2000-3 Arapaho Road
PUNCH LIST - 2000

TOWN OF
ADDISON

Re: Arapahoe Rd Punch list

Arapaho 5/18/00 Kevin Chambers, EBC

TYPICAL QUORUM SIDEWALK PLAN DETAIL (A)  
 1/2" = 1'-0"

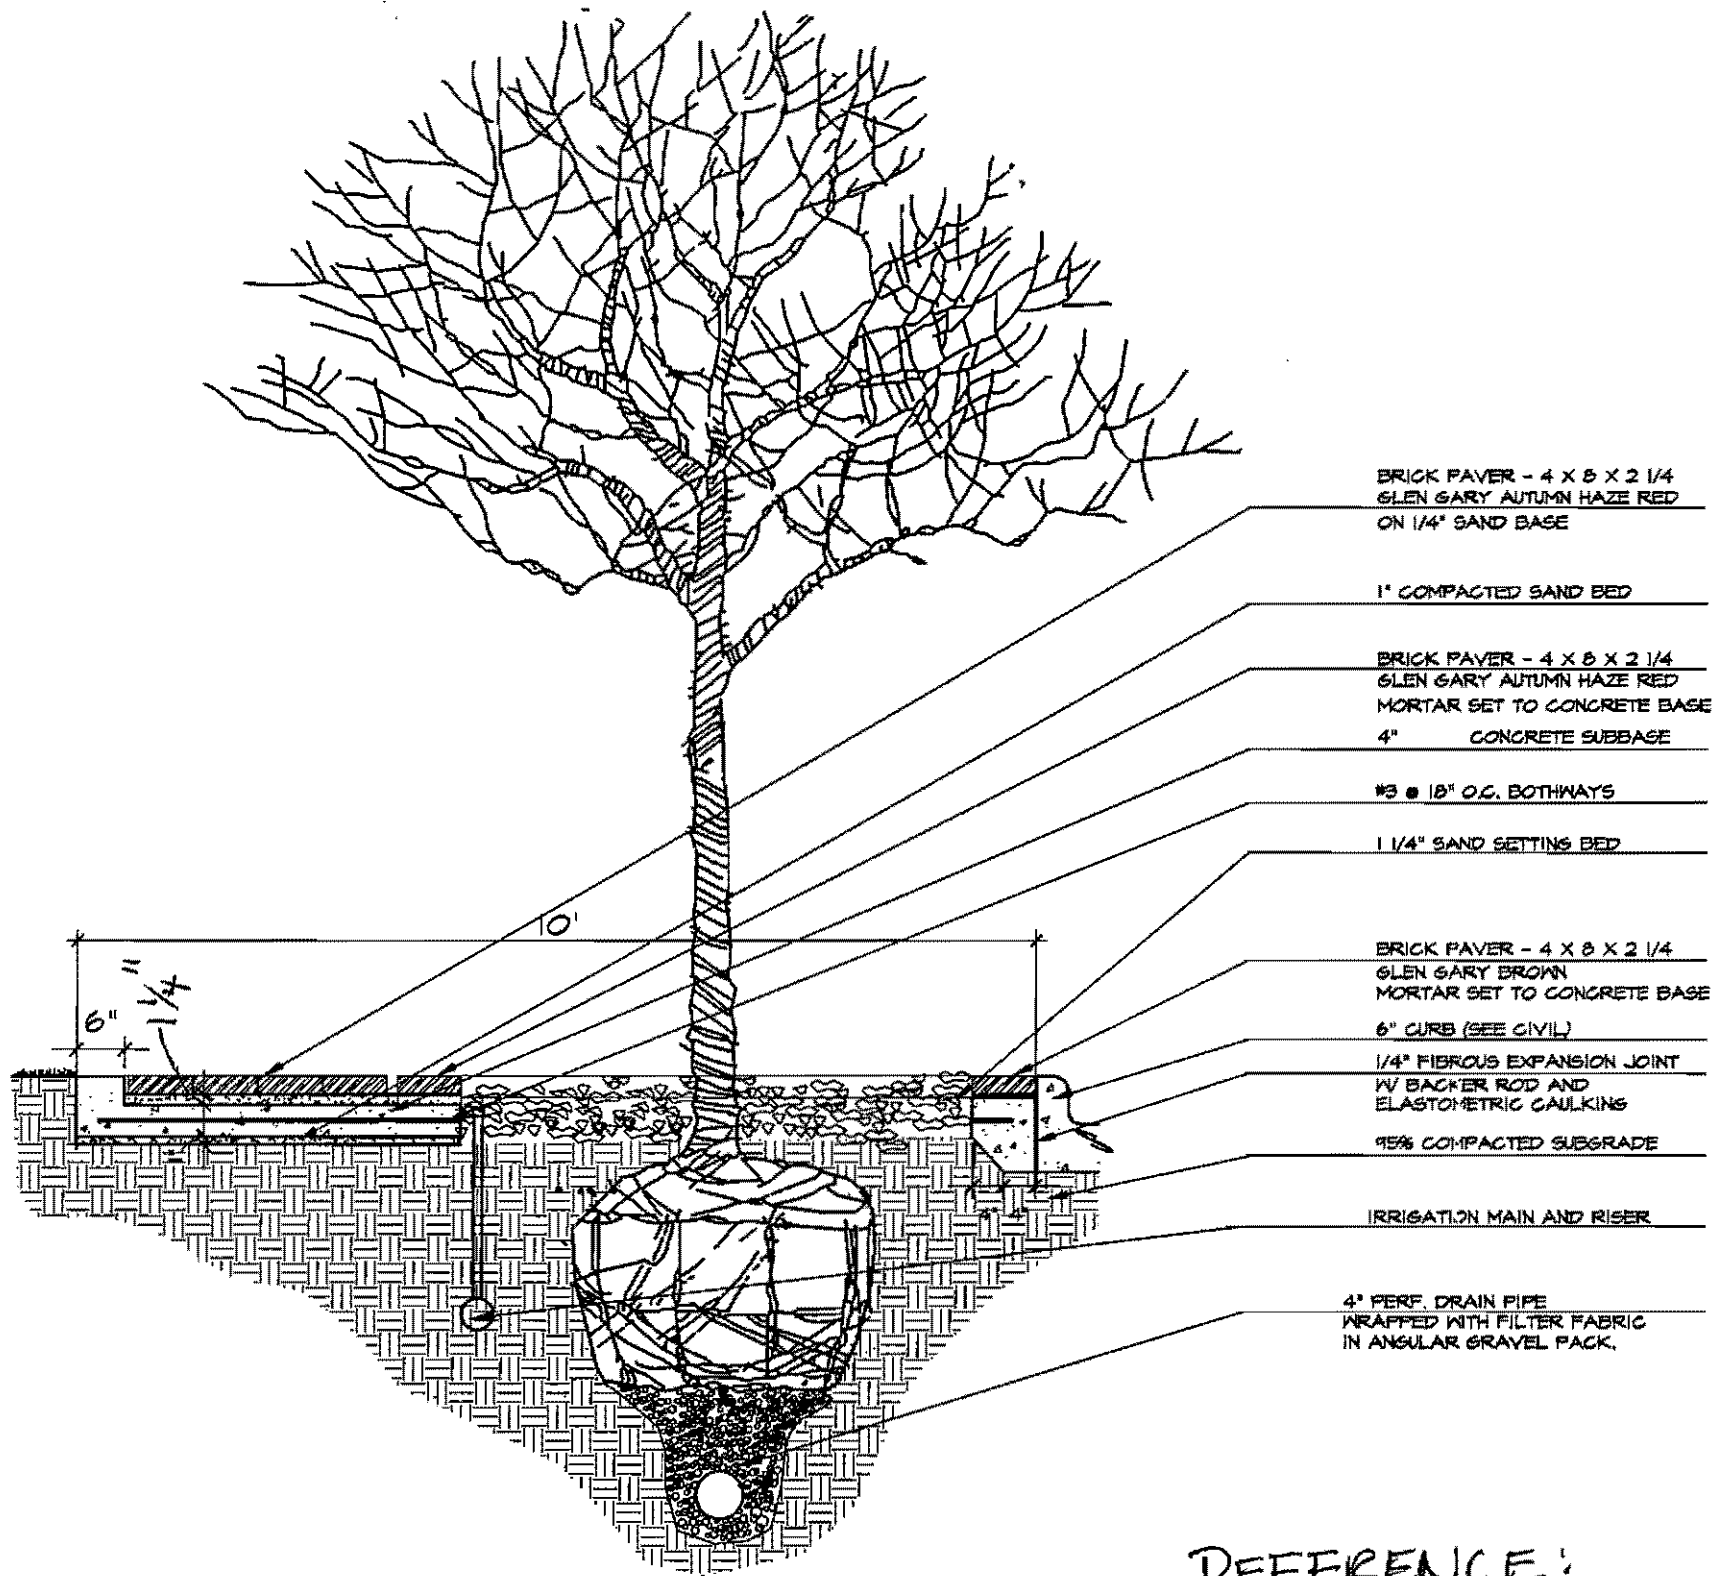
Section Thru Tree Well Quorum Drive

Edge bricks are not fixed solid to base concrete. If you step on an edge brick it will move.

Originally, these brick were all supposed to be laid on a bed of mortar. That was changed to a bed of sand under the condition 3 or 4 courses of brick around the tree wells would be laid in a bed of mortar to "fix" them in place. The contractor advised that in his experience, only one course of brick around the tree well would need to be in a bed of mortar, and he supposedly has done that. At this point, the edge bricks are not satisfactory.
